RMG Response Letter to—Development Plan and Final Plat for Northcrest Flex Space PPR

PCD File No.: PPR-21-036

Sixth Review Letter

Subject: Northcrest Flex Space
2510 and 2522 Canada Drive
Colorado Springs, CO 80922

JOB NO.: 180649  
SHEET NO.: C-06

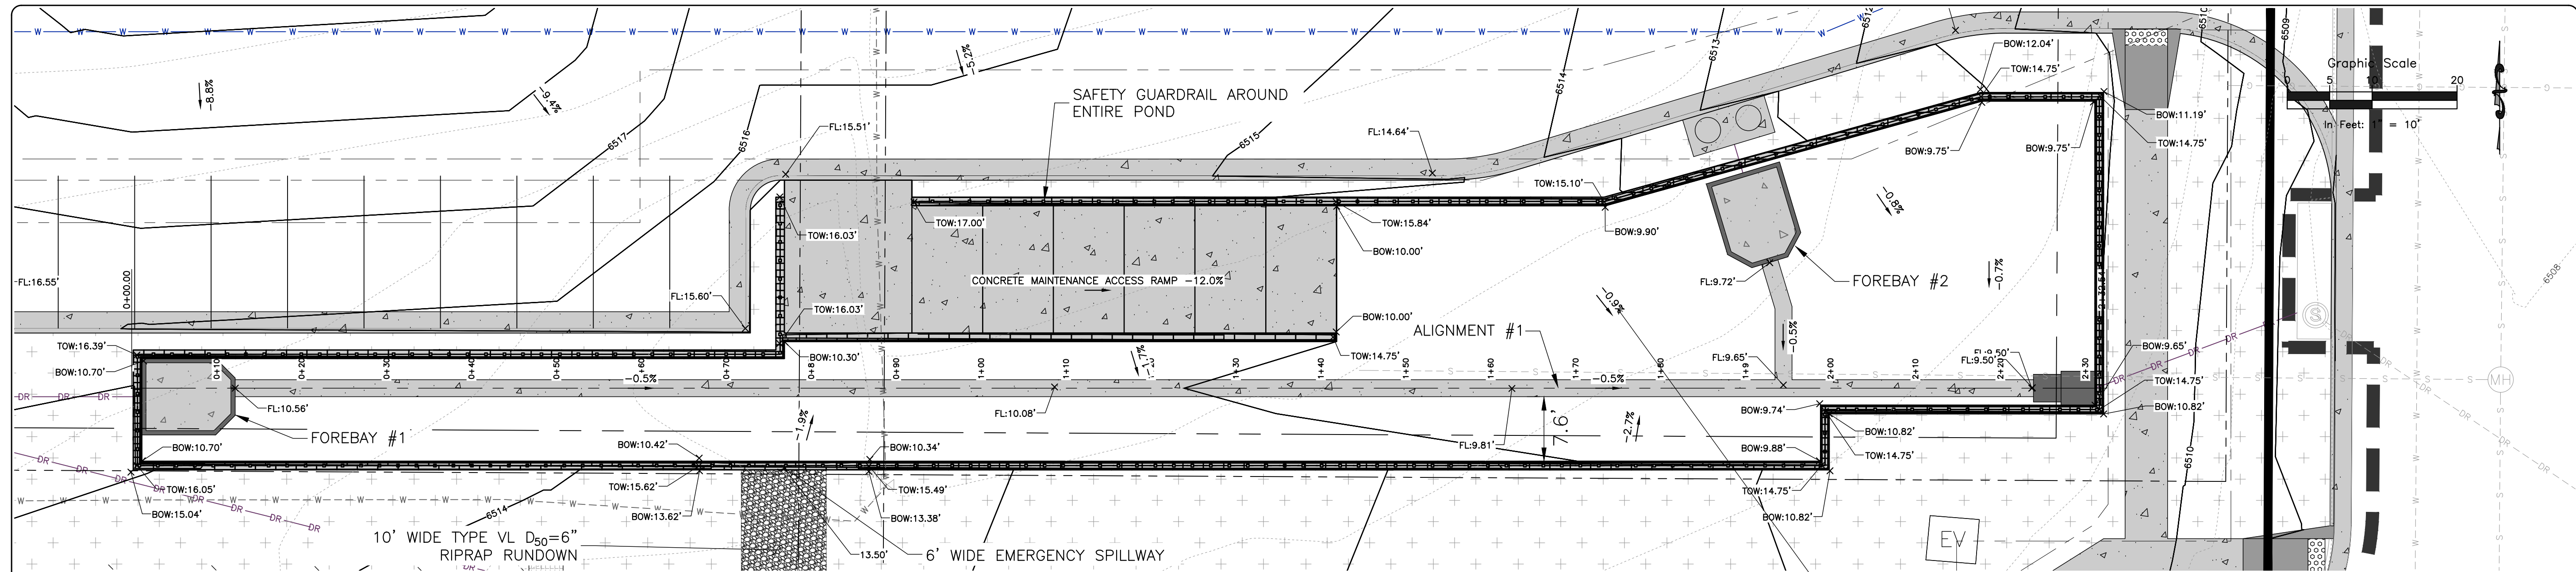
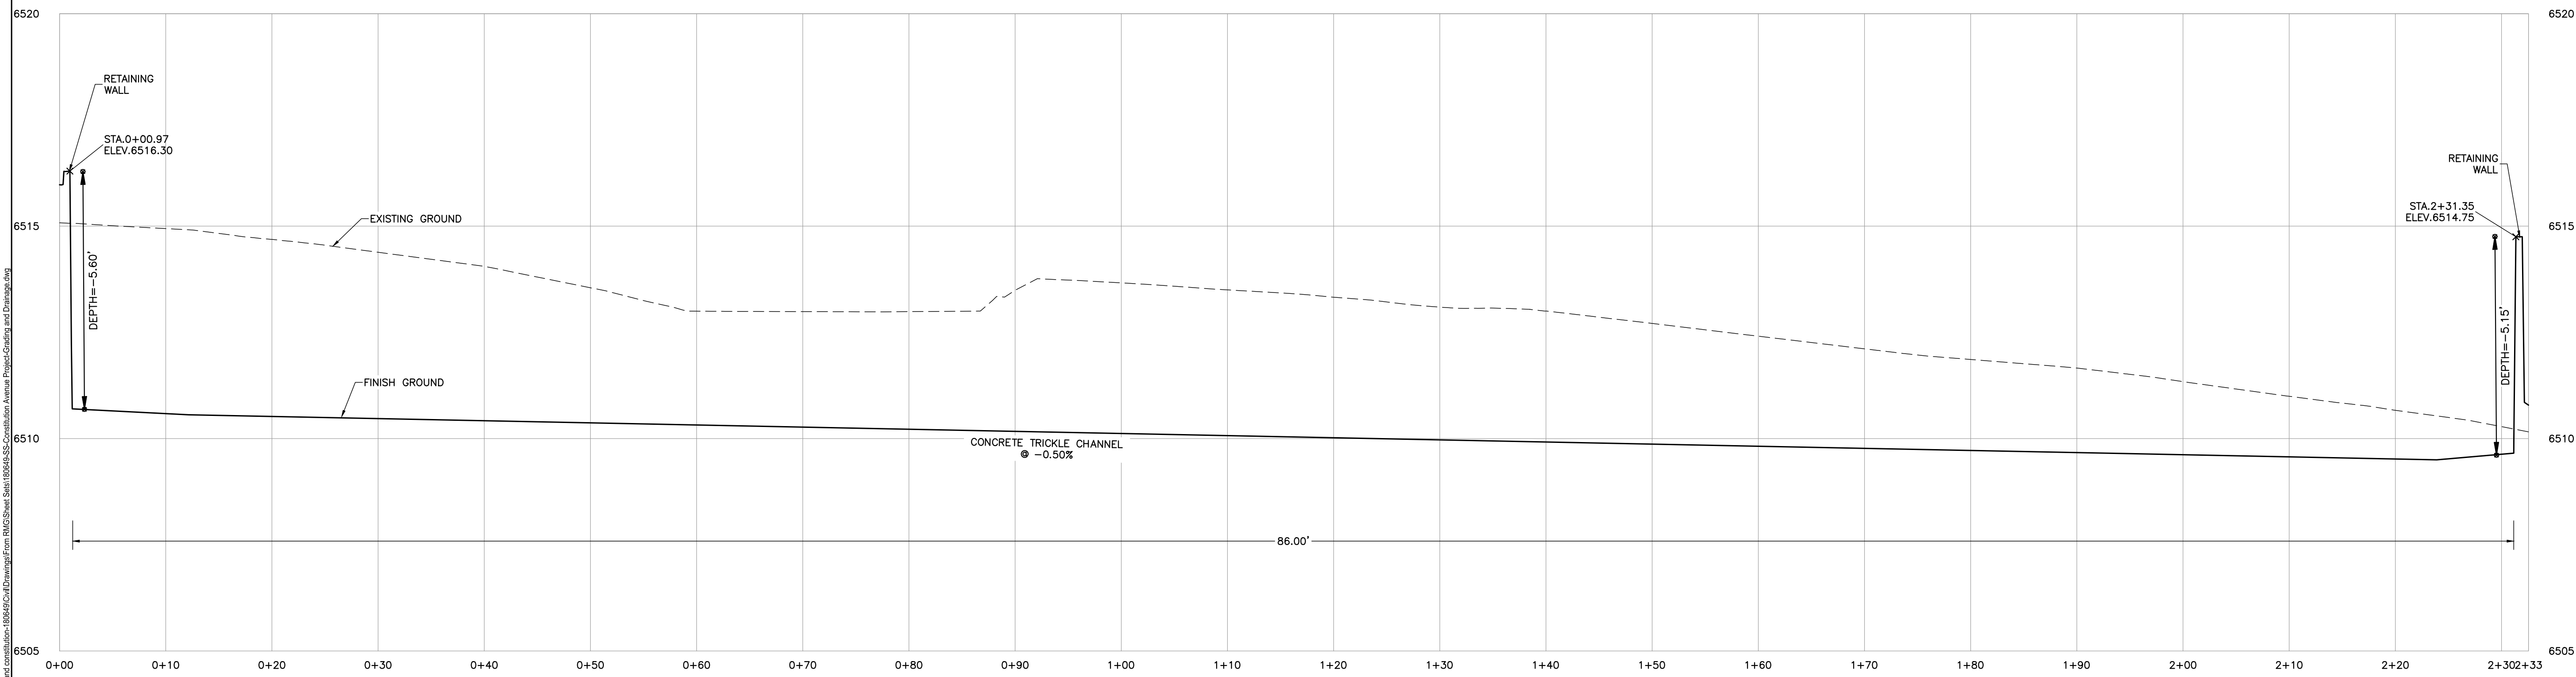
2. Pond Bottom Should have a minimum slope of 3% to the trickle channel and micropool (USDCM Vol 3, detail T-5). Please adjust to minimize future maintenance needs.

RMG: The grading has been revised on the bottom of the pond.

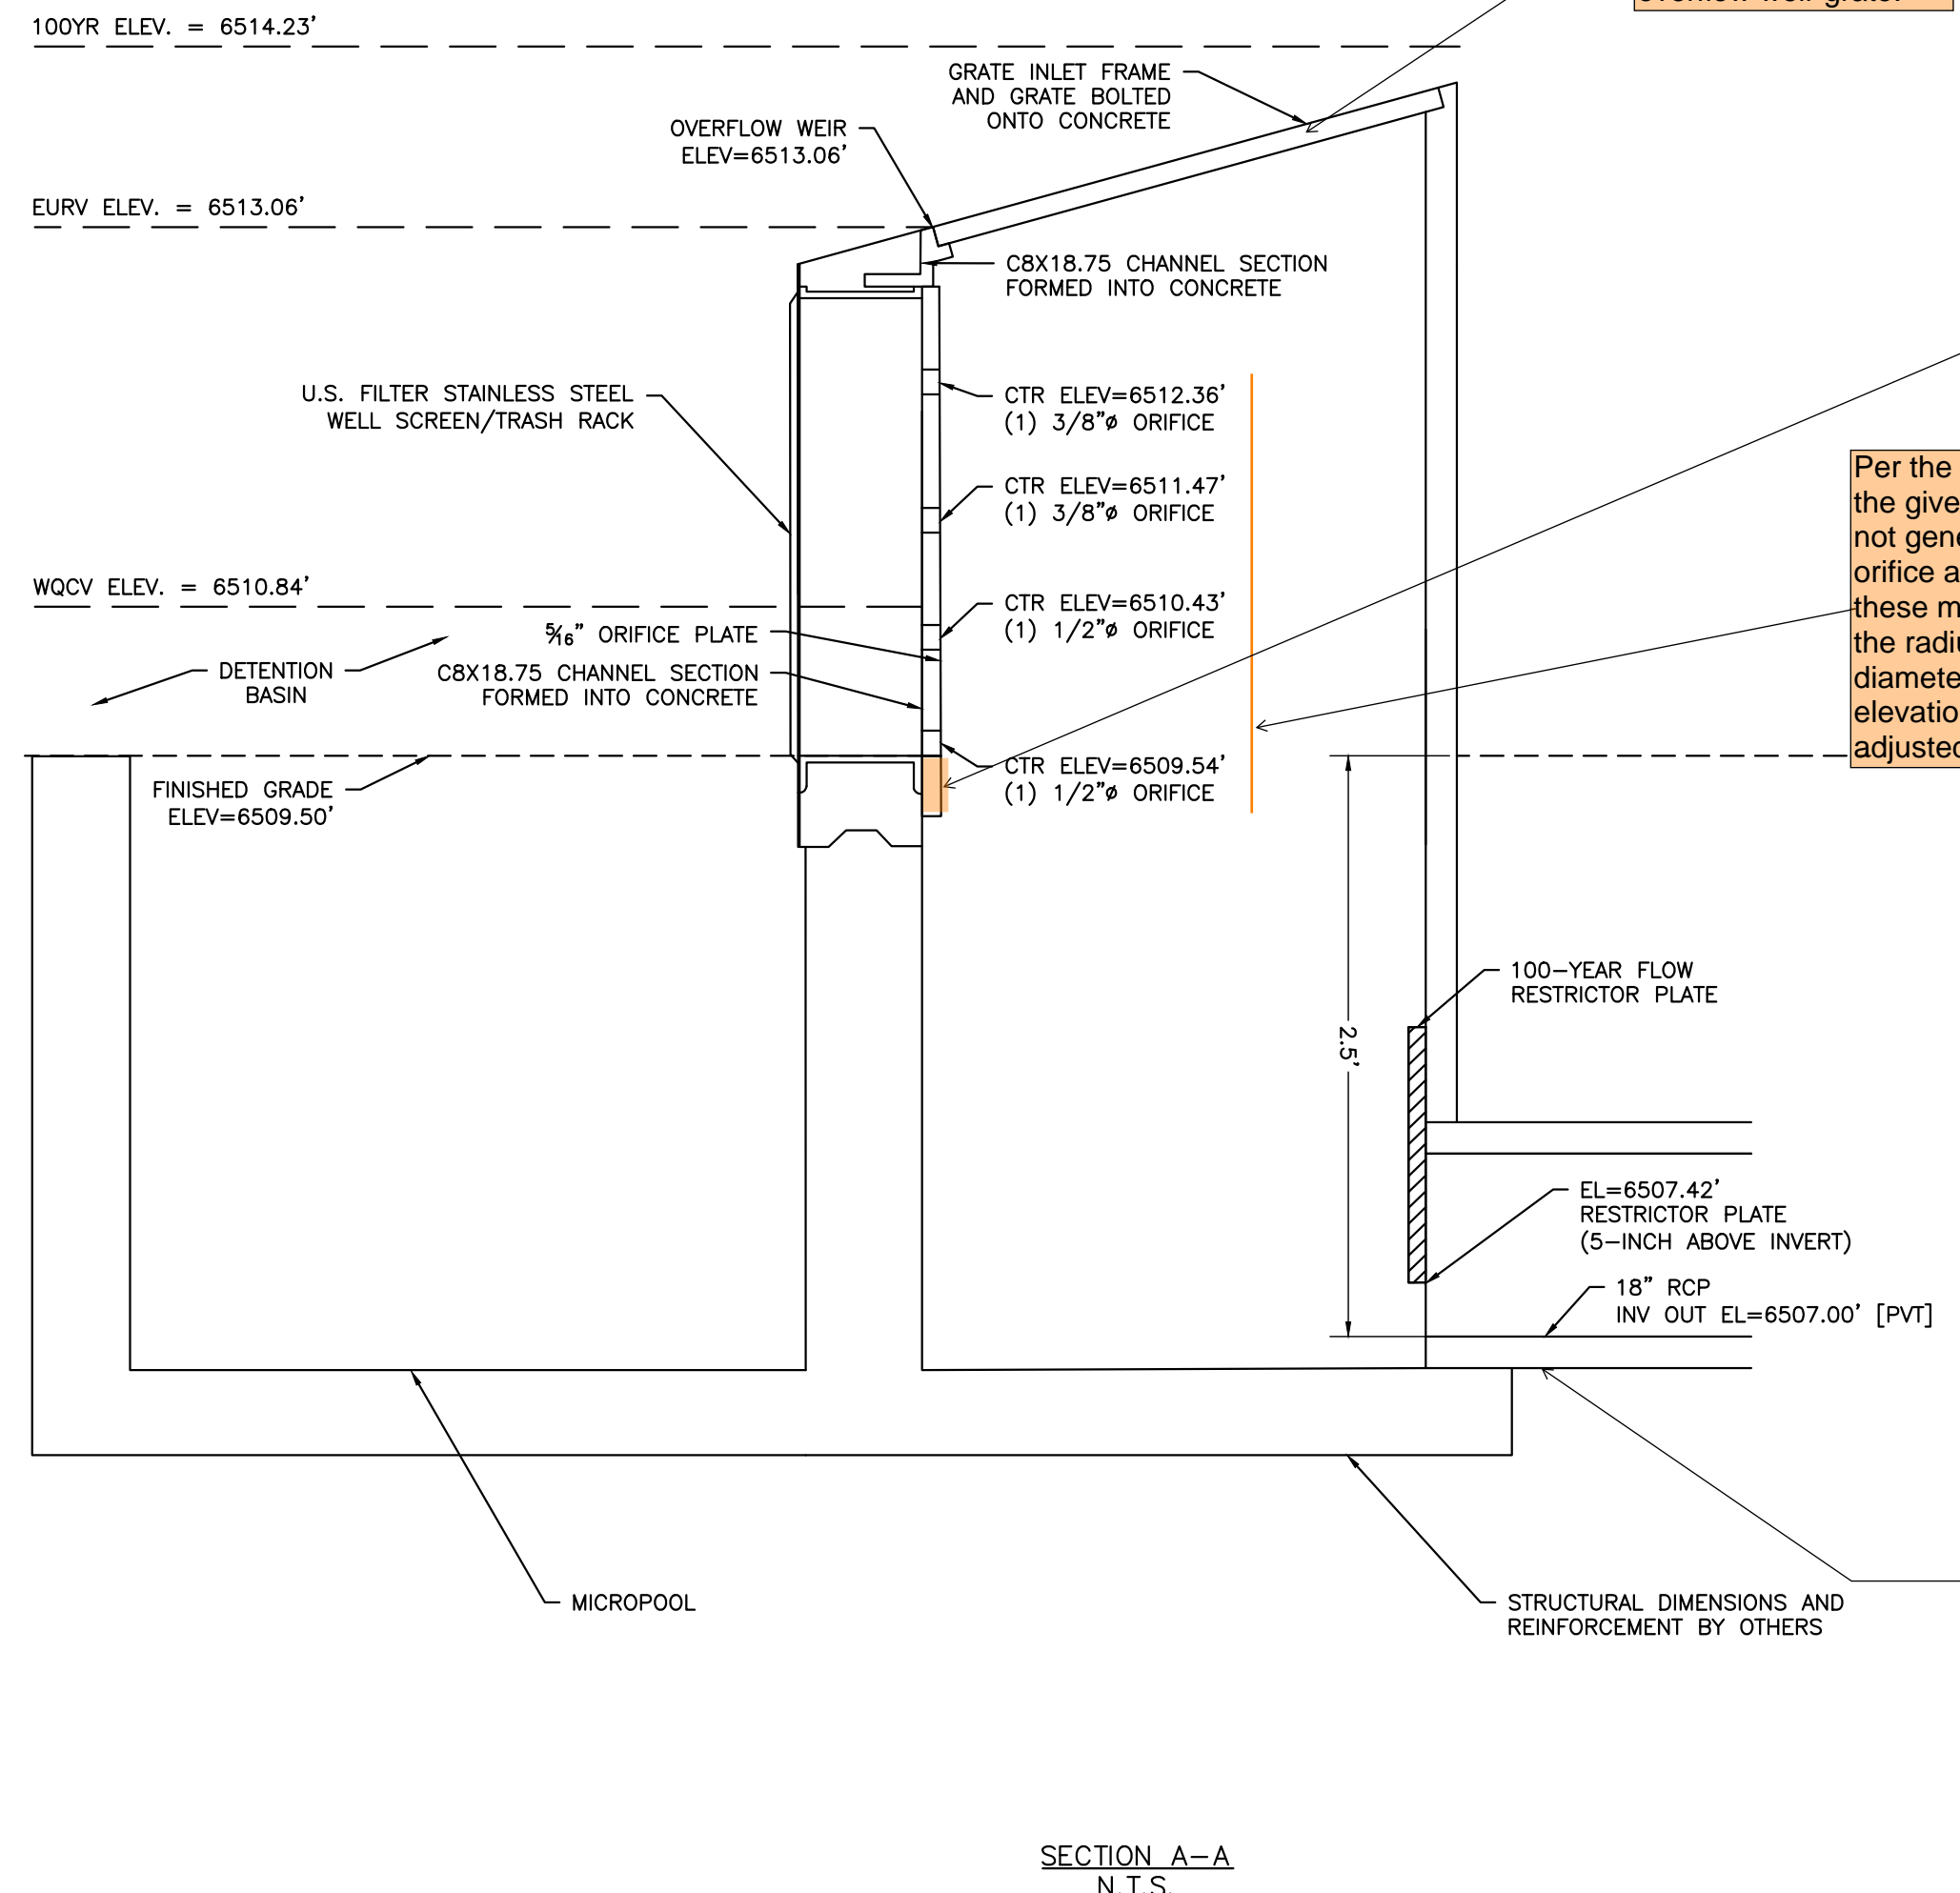
3. There are no dimensions provided for the outlet structure and contradicting information between the GEC DR and pond plans.

4. Show bolt locations on top and bottom of plate. Orifice plate requires a gasket or sealant to ensure a watertight seal with the outlet structure.
RMG: This has been shown.

6. Drainage report MHFD calcs state that there is no slope on the overflow weir grate
RMG: The MHFD calcs have been revised.
7. Per the drainage report, the given diameters do not generate the required orifice area. Looks like these measurements are the radius, not the diameter. All center elevations should also be adjusted accordingly.
RMG: These have been revised to match the drainage report

8. The orifice plate is longer than shown here. These plates are expensive and have a long lead time. Additional information (dimensions) should be provided to ensure that the proper size plate is ordered.
RMG: This has been revised and more information has been included.

RMG: Dimensions have been provided and information has been revised to match.
